Re: NM Sol/ Phase 1 Tenant Addition
7402 Los Volcanes Rd. NW
Traffic Circulation Layout
Architect's Stamp 03-28-23 (J10-D027)

The following are our responses to your 2nd round of comments on the above TCL.

**TRAFFIC CIRCULATION  
LAYOUT APPROVED**

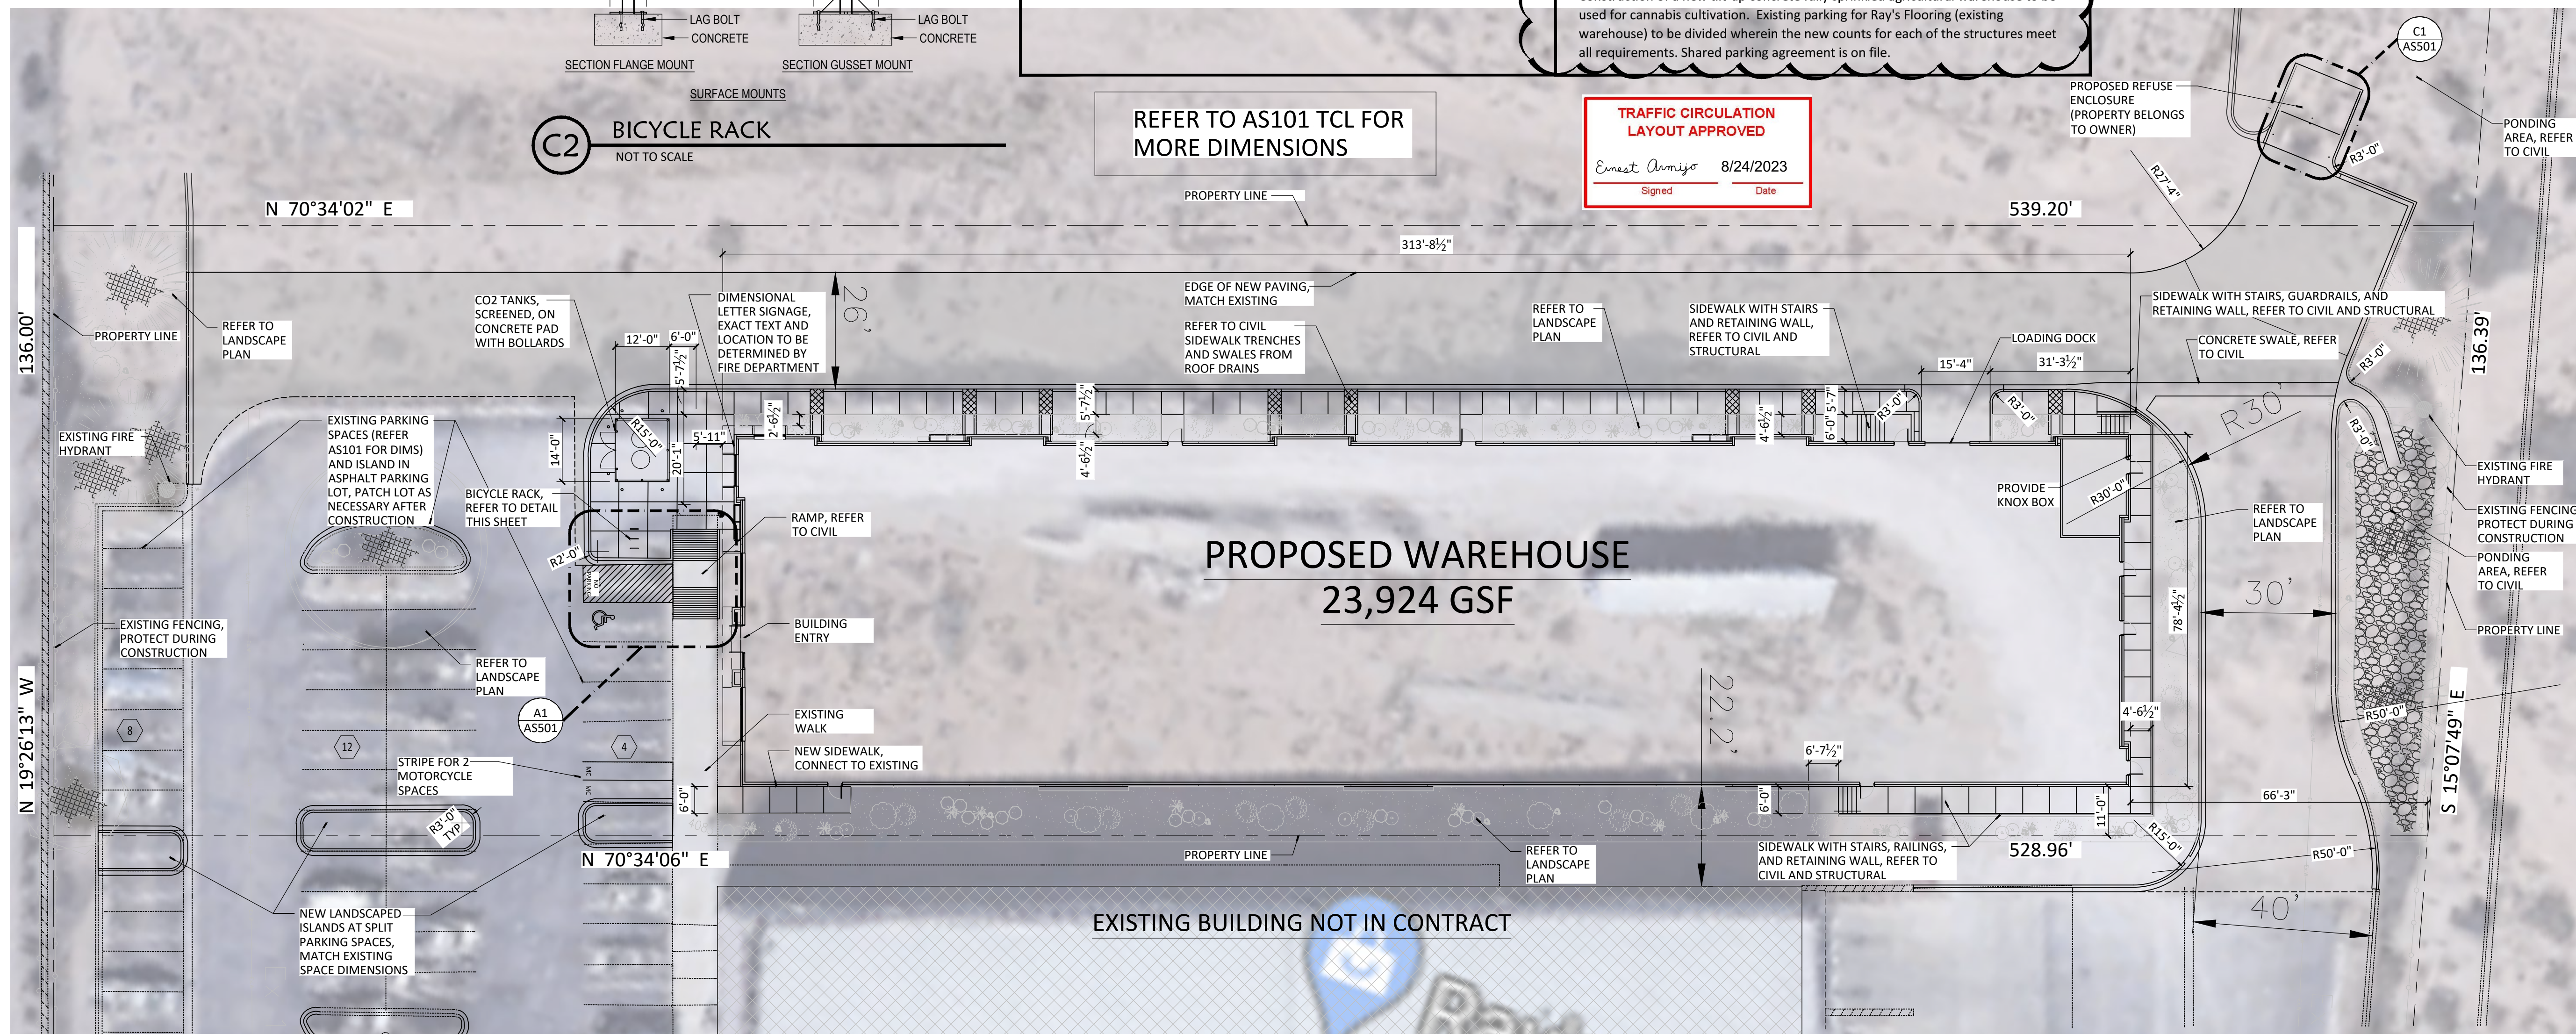
1. Site accesses must be updated to current ADA standards and have truncated domes installed.
 - a. Note added to AS101
2. Due to proposing property line, Please clarify, do you have an approved plat? If so, please provide an approved plat showing shared accesses and parking agreement.
 - a. We are waiting on plat approval and will upload the document when we receive it. Attached is the parking agreement (although we have enough spaces).
3. The existing ADA parking spaces at the west side of the existing warehouse must be updated to current ADA standard.
 - a. Note was added to AS101
